REVIEW OF LANDSCAPE AND VISUAL APPRAISAL

CHERWELL DISTRICT COUNCIL

Application reference: 22/03873/F – Padbury Brook

**Review of LVA
22/03873/F – Padbury Brook**

TITLE:
PV table details

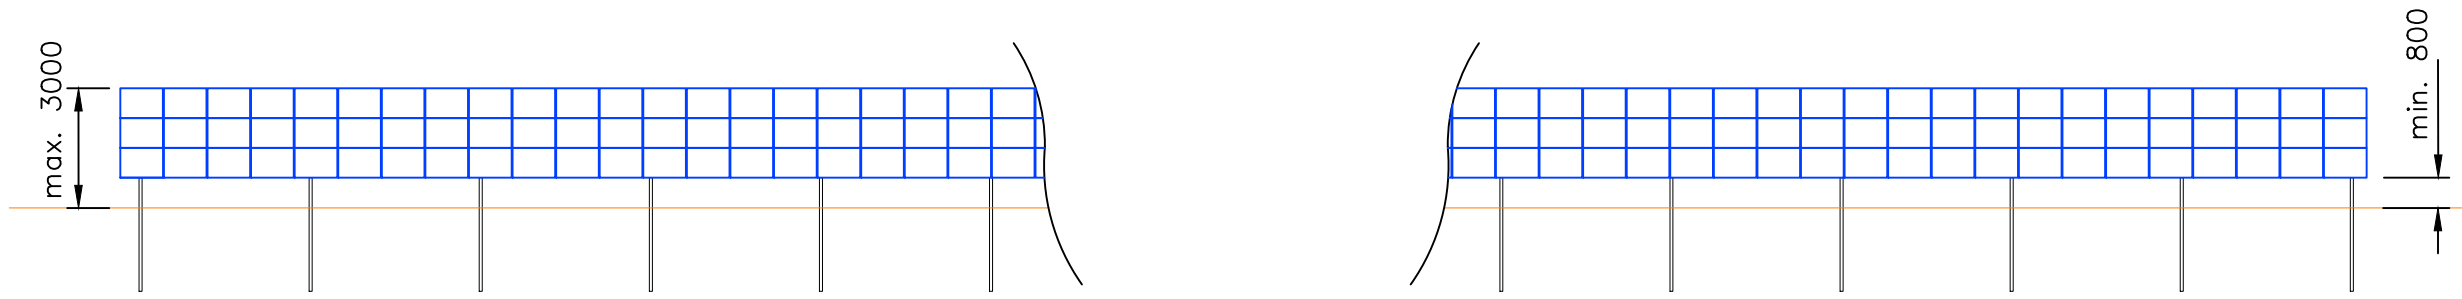
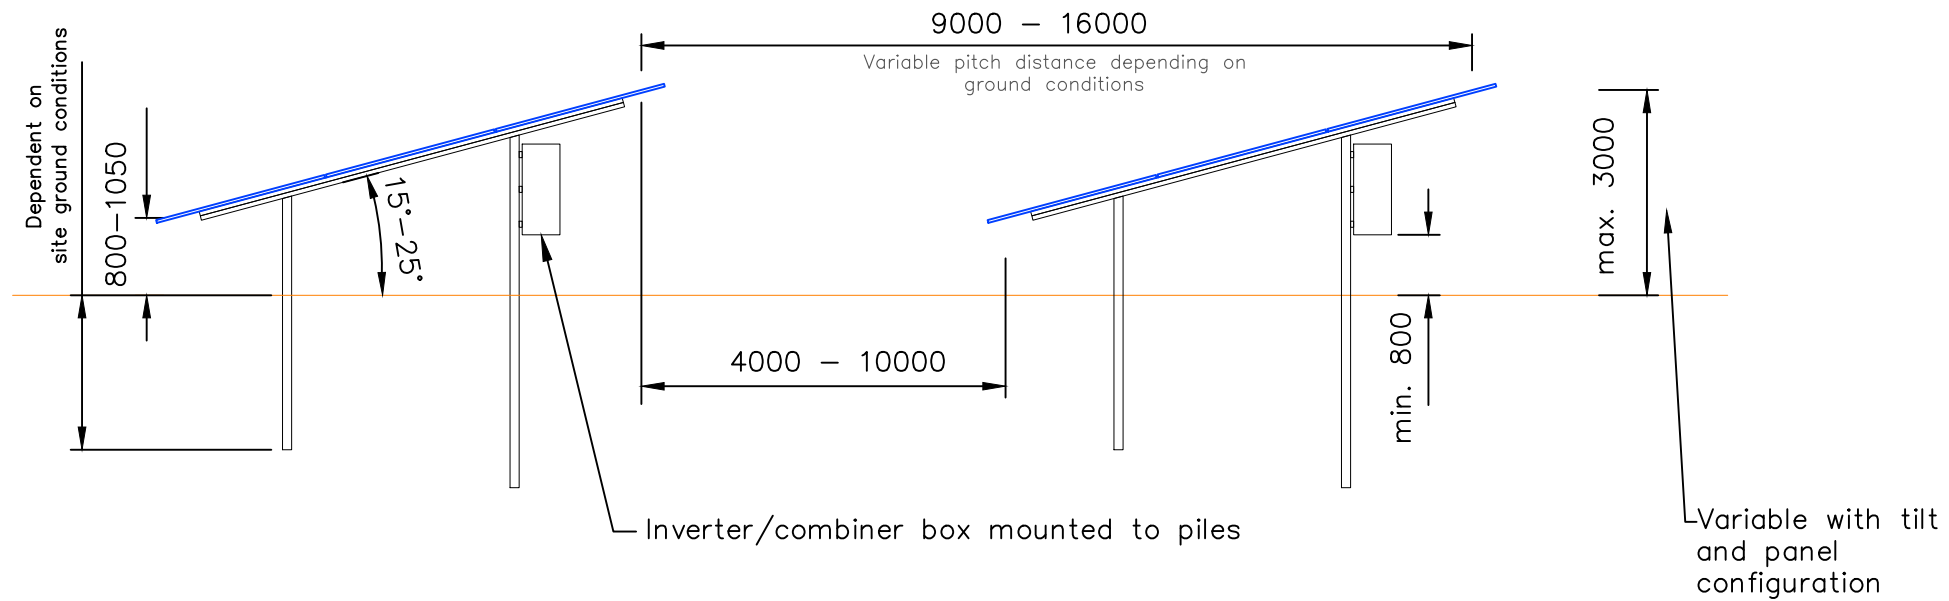
- 2.22 The LVA notes at para 3.2 that for the "*design of the Arrays, a tracker system will be utilised to orient the panels towards the sun throughout the day*". In this brief review no other reference to this feature has been noted and, in places, the panels are referenced as fixed. It would be helpful to have some information on the degree of movement and if or how this alters the overall height of the panels which could potentially alter their prominence during the day.
